Forestry Corporation of NSW ABN 43 141 857 613
Western Region
168-172 Brisbane Street
Dubbo NSW 2830
(PO Box 865 Dubbo NSW 2830)
T: 0410 149 385
E: jarod.dashwood@fcnsw.com.au
www.forestrycorporation.com.au

11 February 2021

**RE: INLAND RAIL – NARROMINE TO NARRABRI ENVIRONMENTAL IMPACT
STATEMENT (SSI 9487) – SUBMISSION FROM FORESTRY CORPORATION OF NSW**

Figure A1.2 Key features of the proposal (map 1)

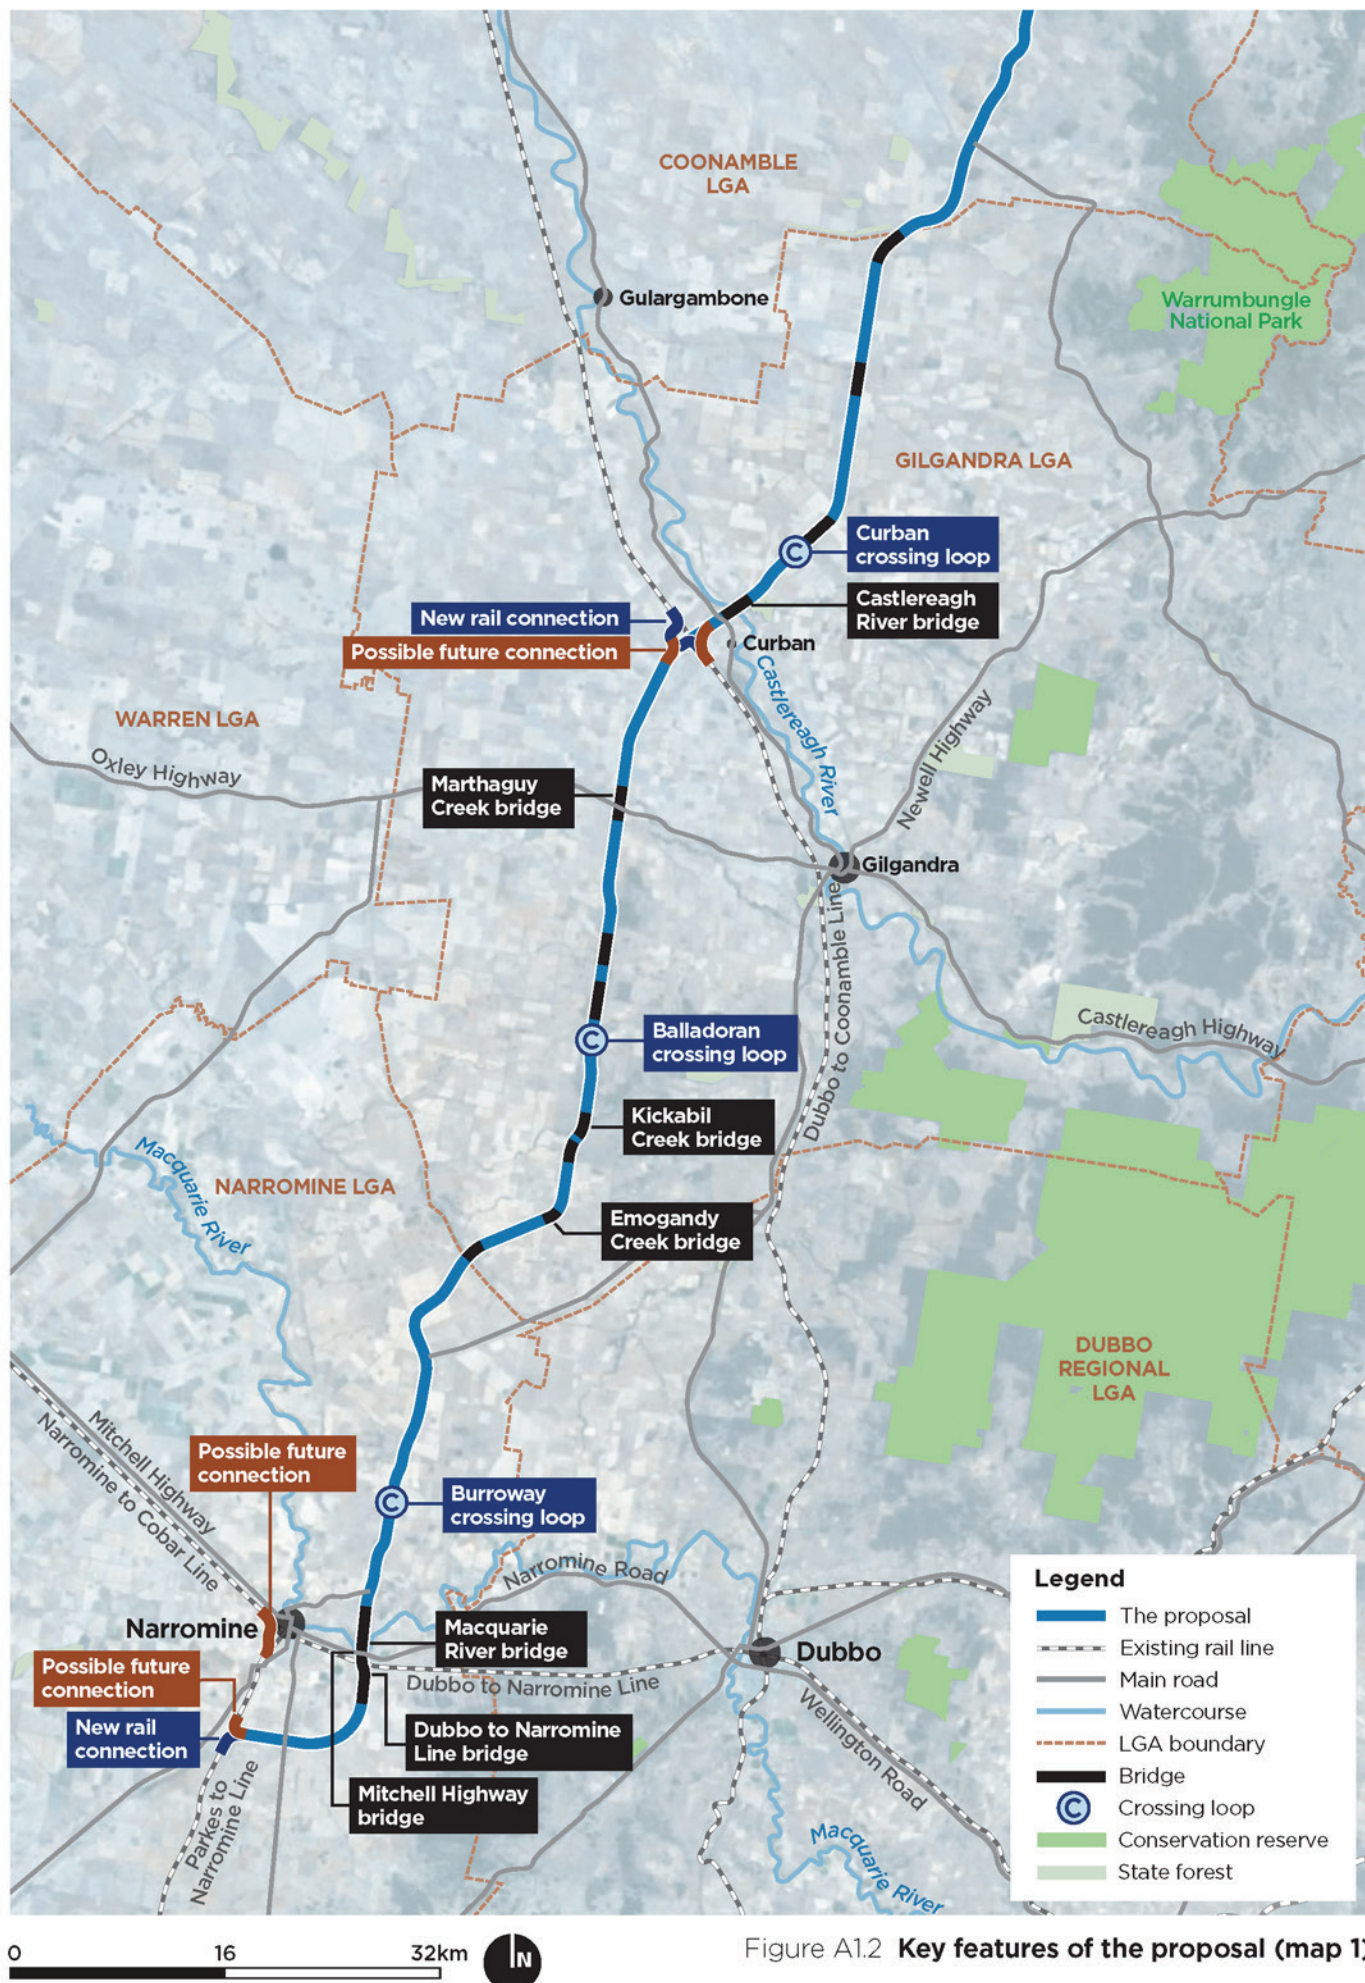
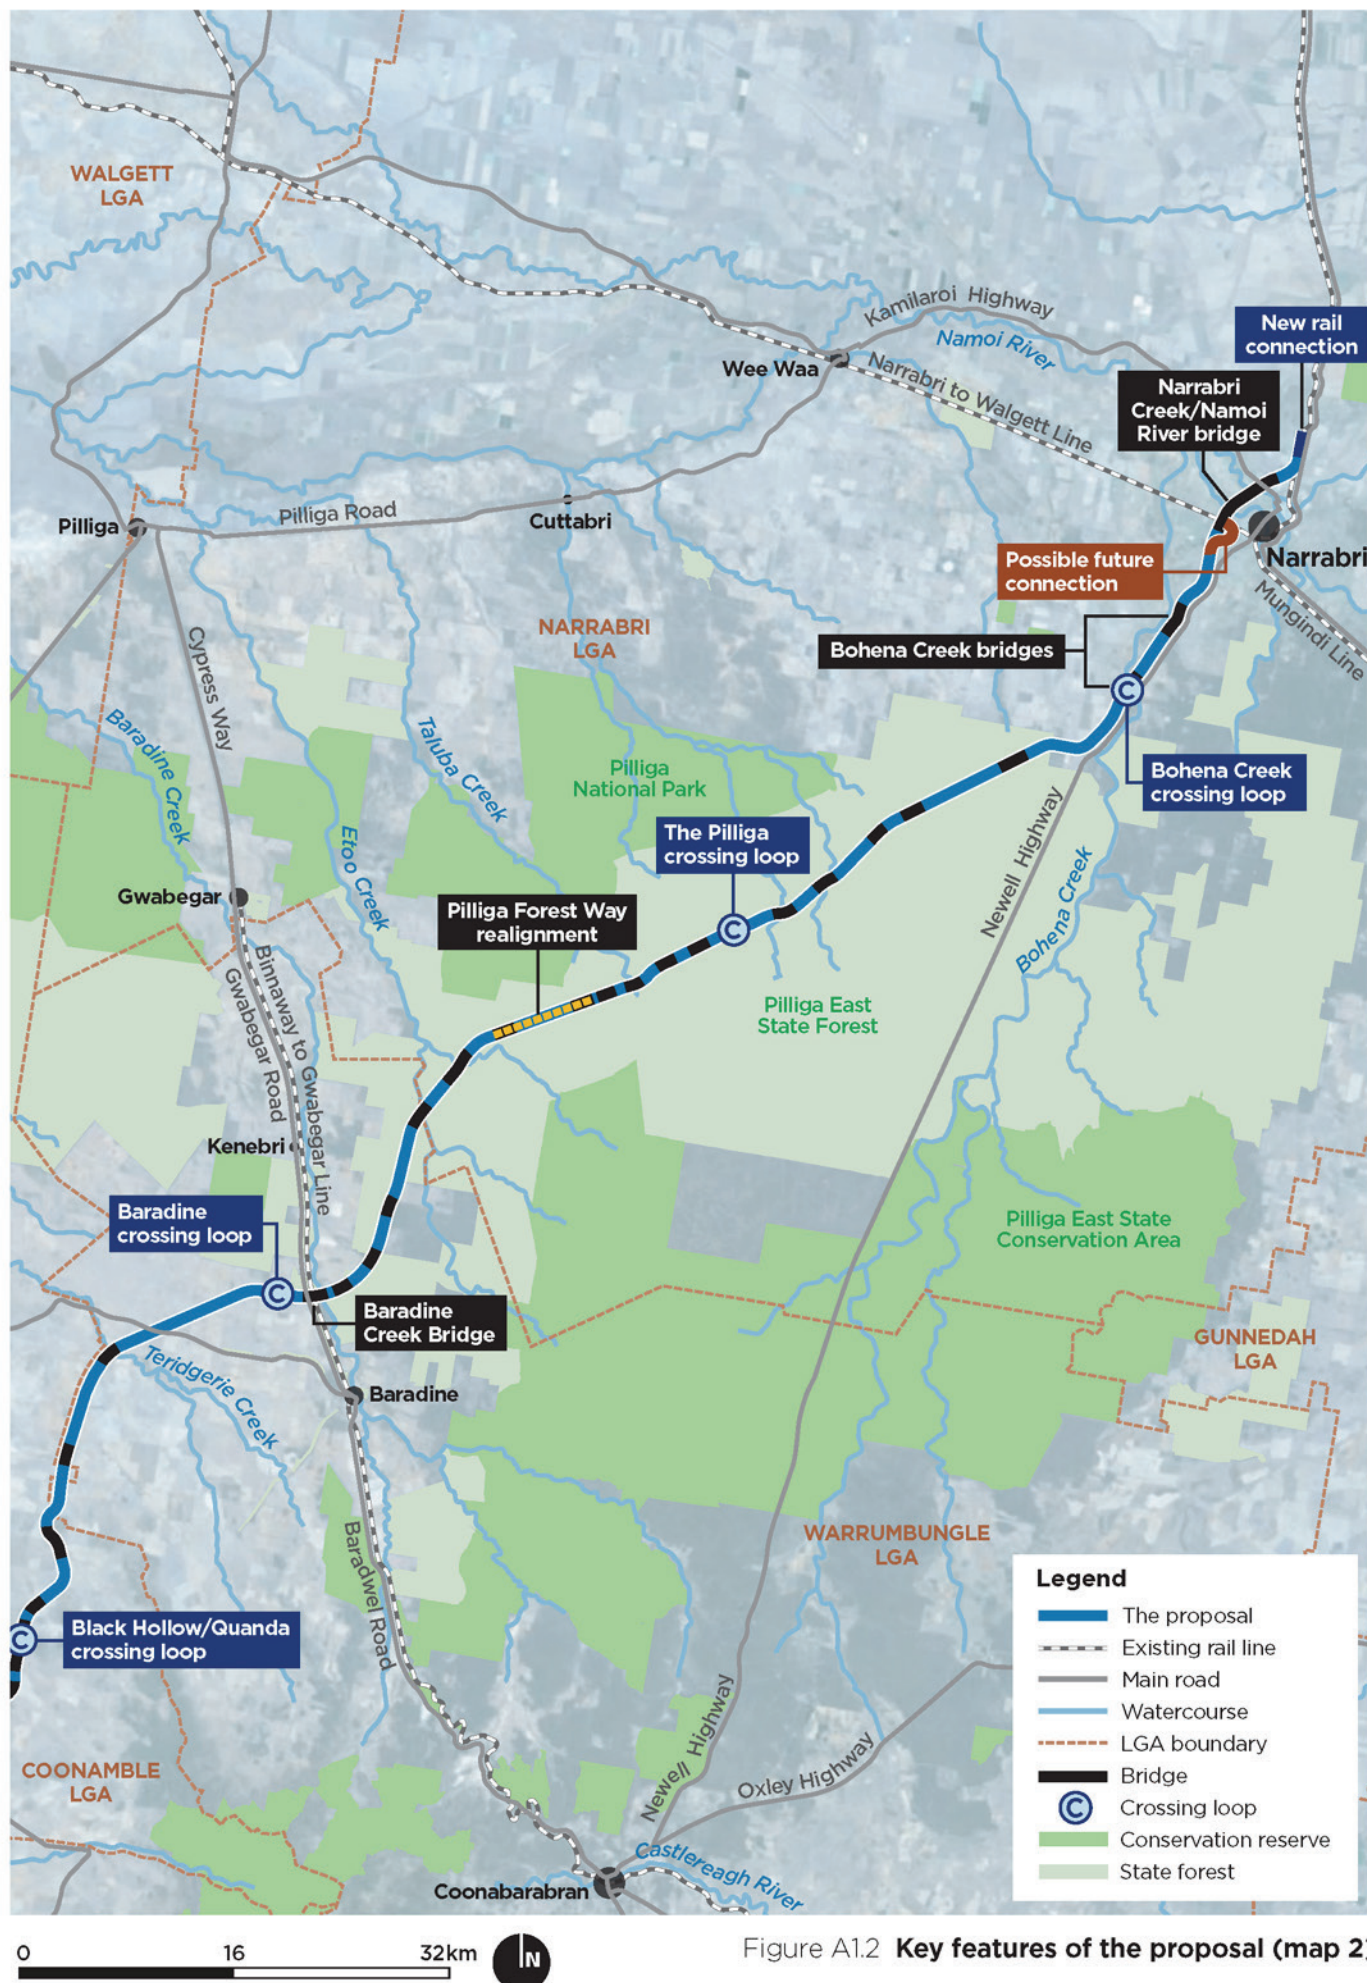
- 2.4. FCNSW and ARTC will need to hold further discussions including field investigations regarding the 6.7km realignment of Pilliga Forest Way (as is proposed in the EIS A1-2). FCNSW would expect that all changes to FCNSWs road network are formalised through a binding agreement between the parties which considers the interests of FCNSW. Does ARTC agree to this process?
